Our Ref: BE/8/20/NMA

Non-material amendment following grant of reference BE/74/18/PL for various external and internal amendments (1 - 8)

1 Finch Gardens Bersted PO22 9EQ

Drawing Title
Proposed Plans - NMA

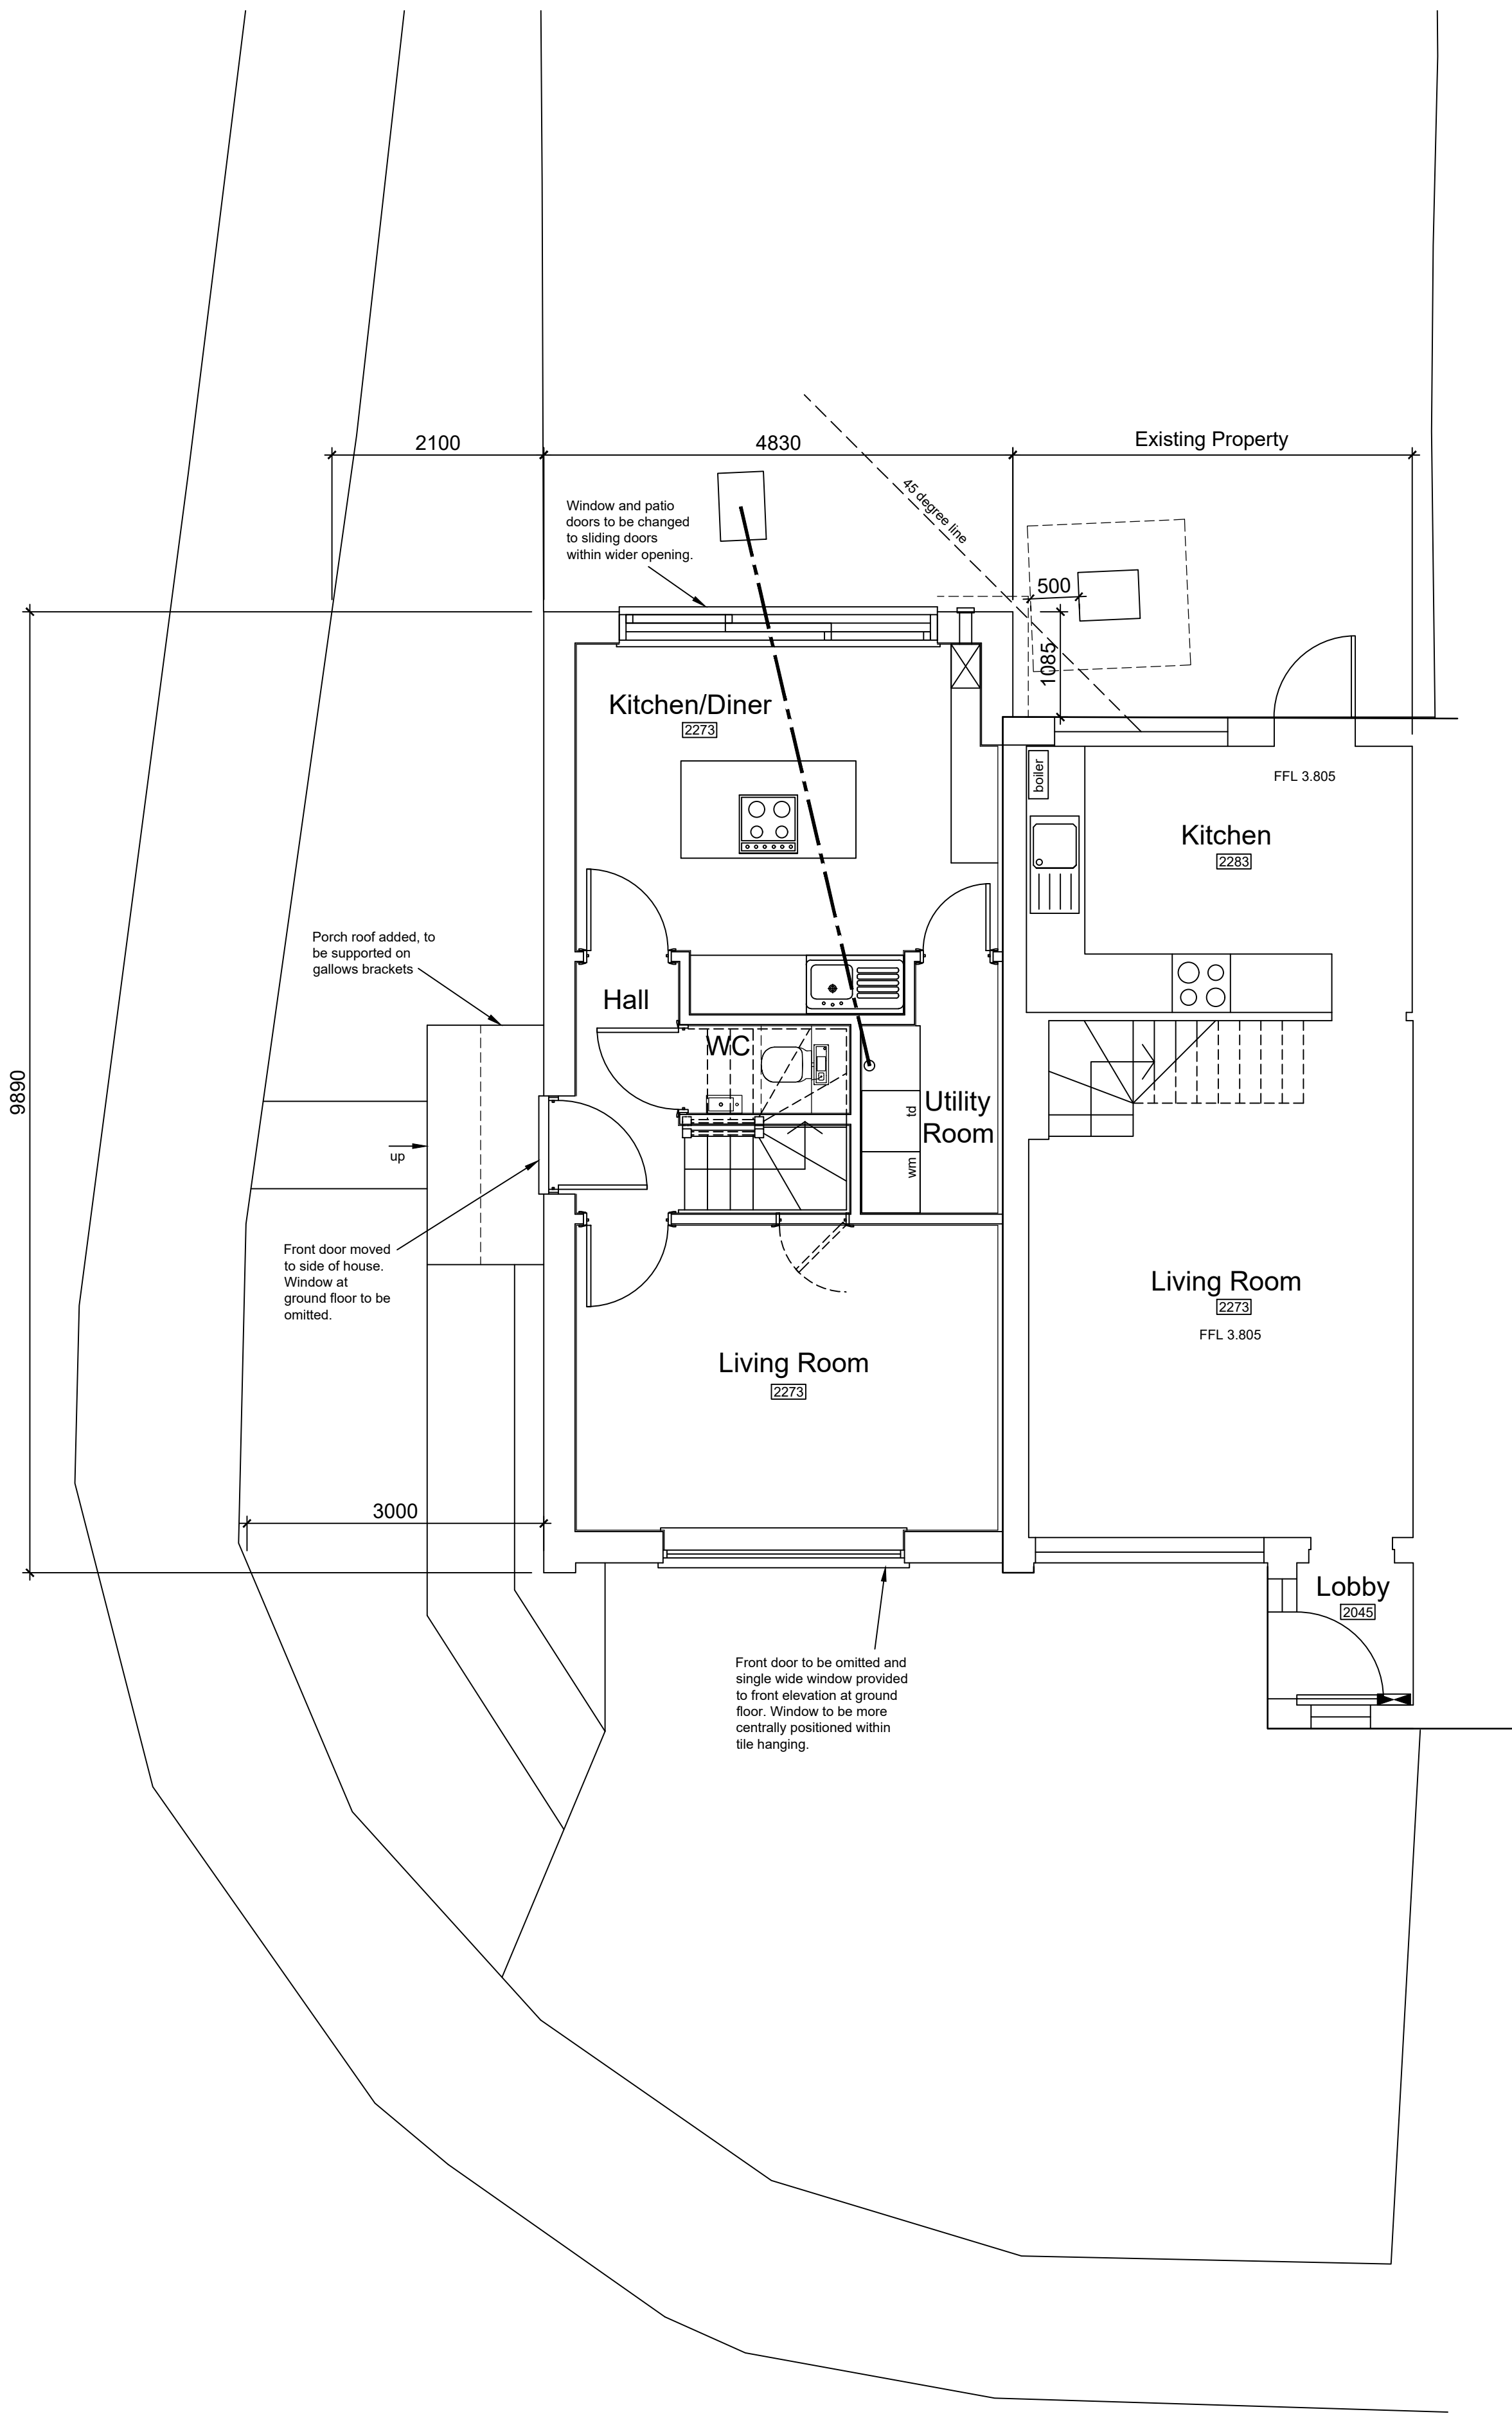
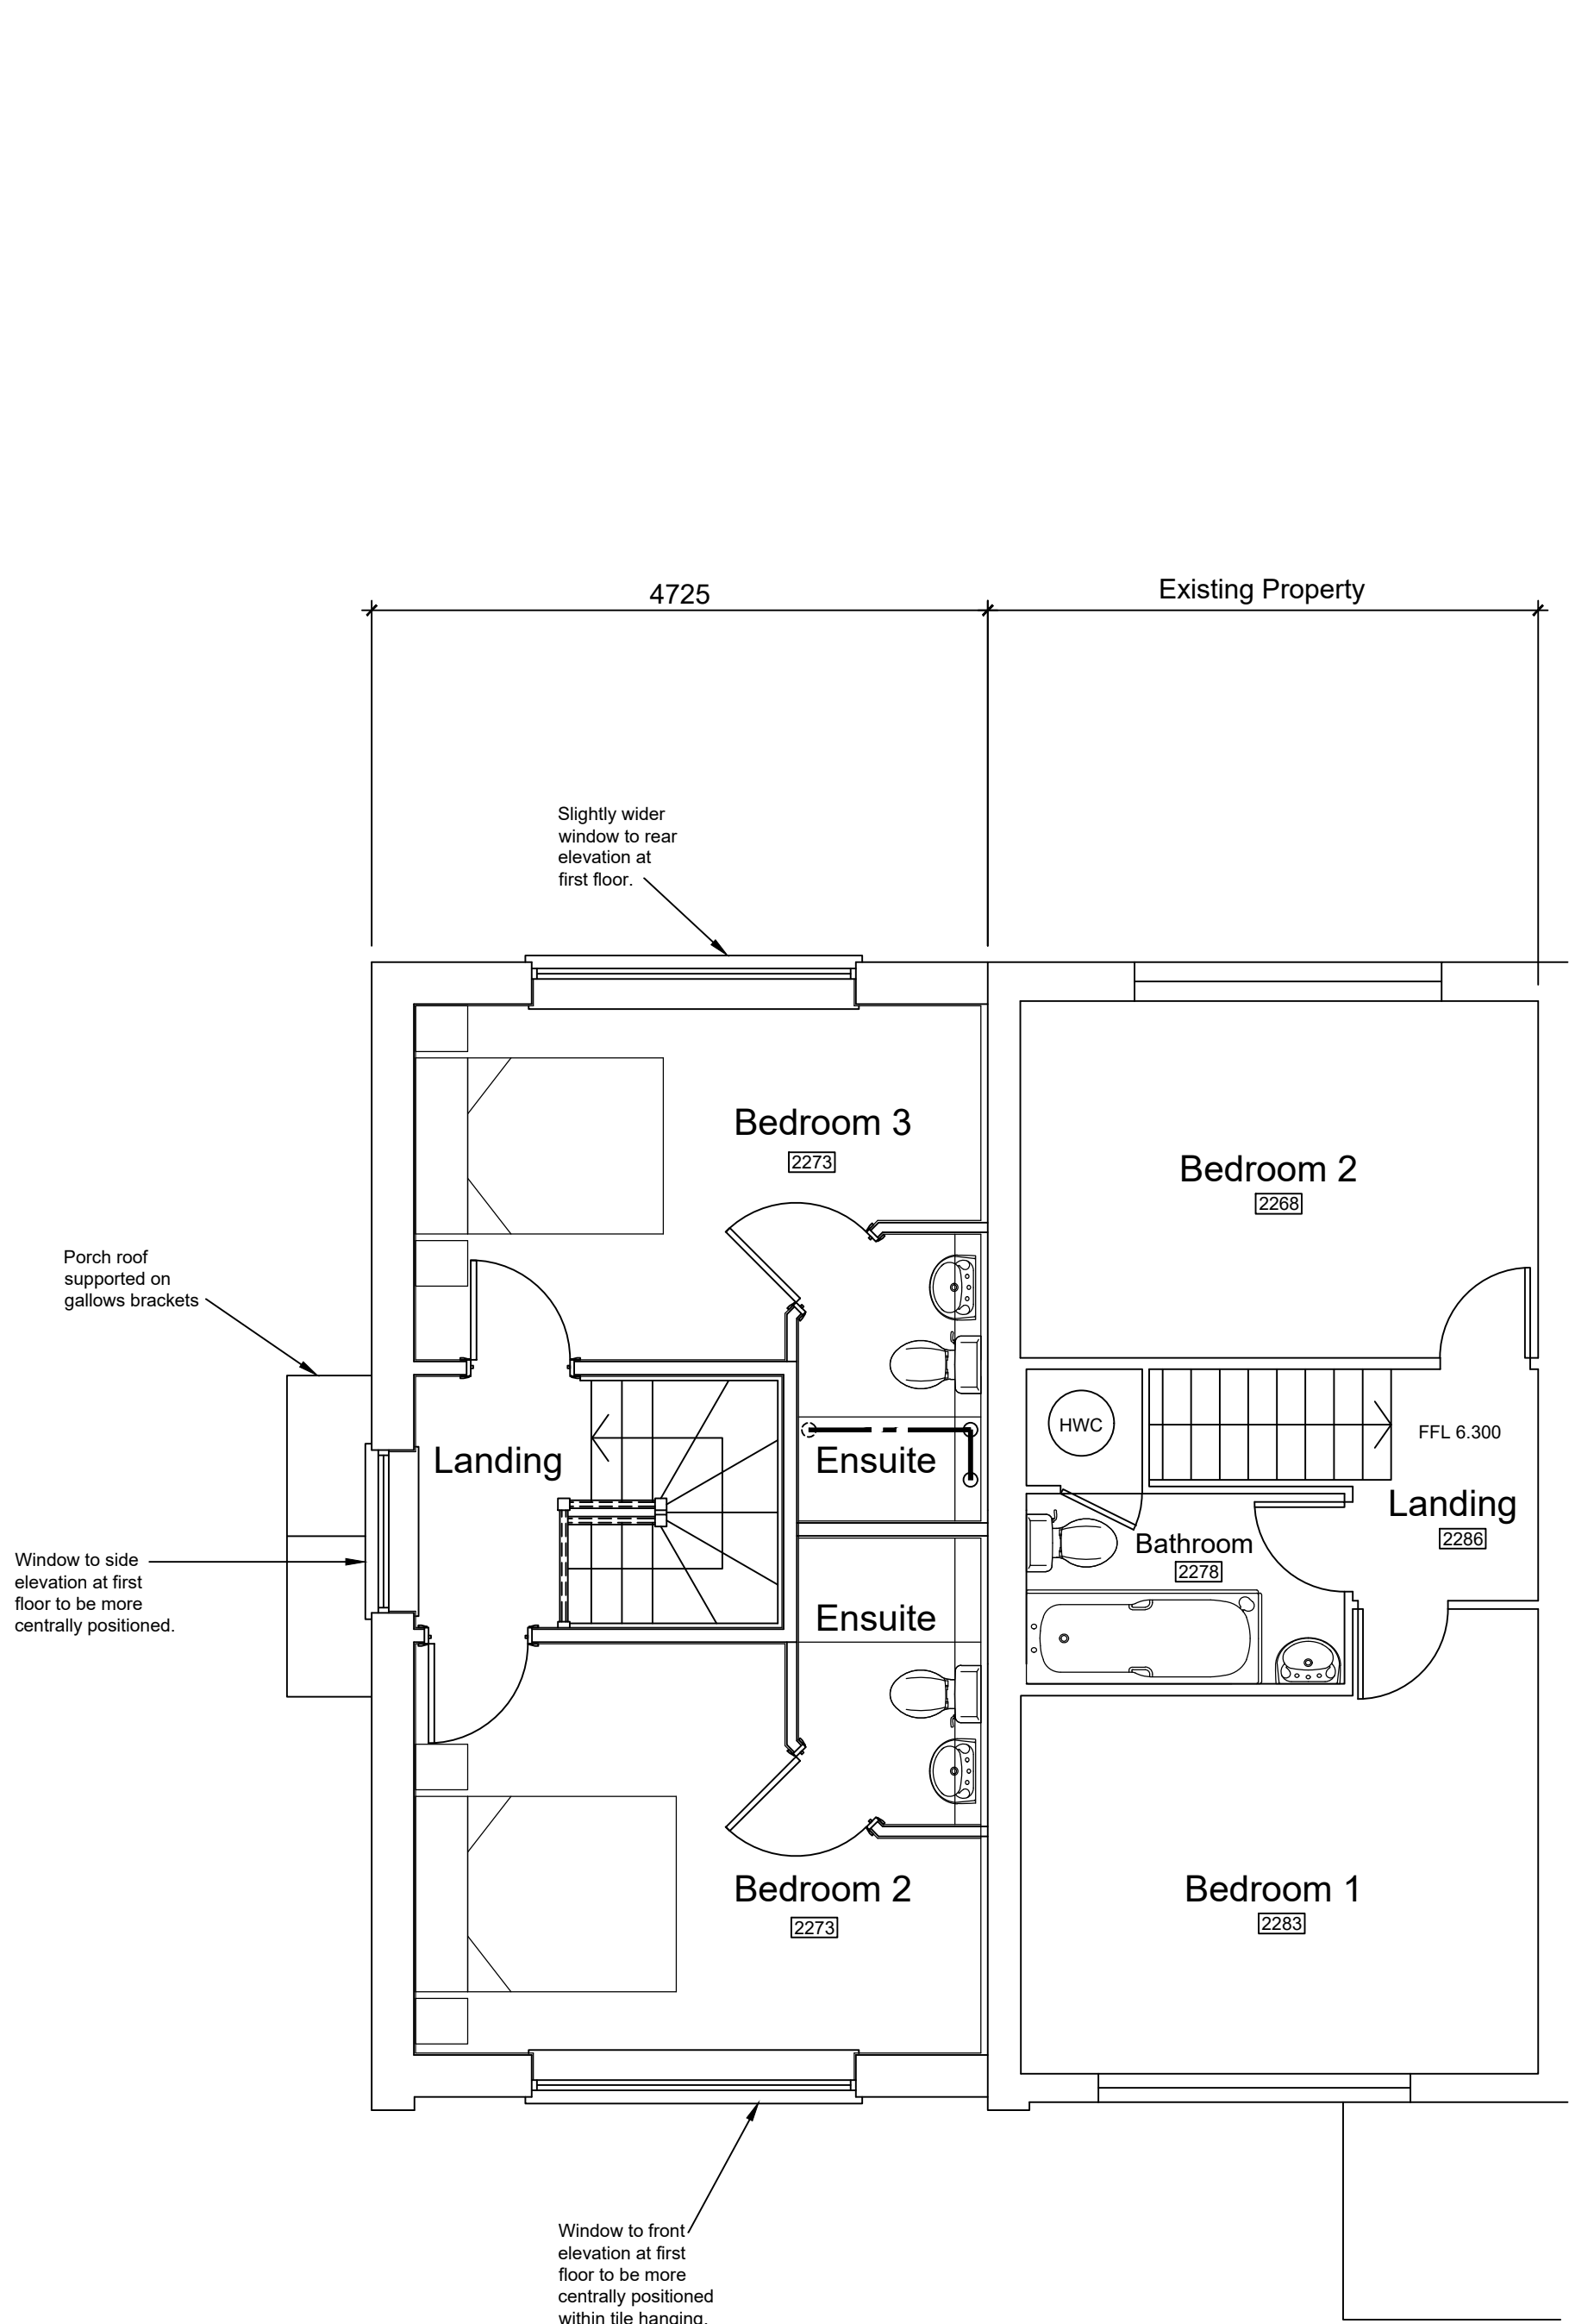
- (a) Front door moved to side of house and new porch roof canopy supported on gallows brackets and new path provided.
- (b) Windows on front elevation decreased slightly in width and centred.
- (c) First floor window on side elevation centred.
- (d) First floor window on rear elevation to be made slightly wider.
- (e) Ground floor door and window on rear elevation to be replaced with sliding doors within a wider opening.
- (f) Short side wall to rear projection to be moved away from existing house by approx. 20mm, so that its foundation can be 500mm clear of public sewer manhole.
- (g) The ground floor rear wall has been moved out by 25mm, so that the long side wall of the house works to brick dimensions.
- (h) Internal layout altered.
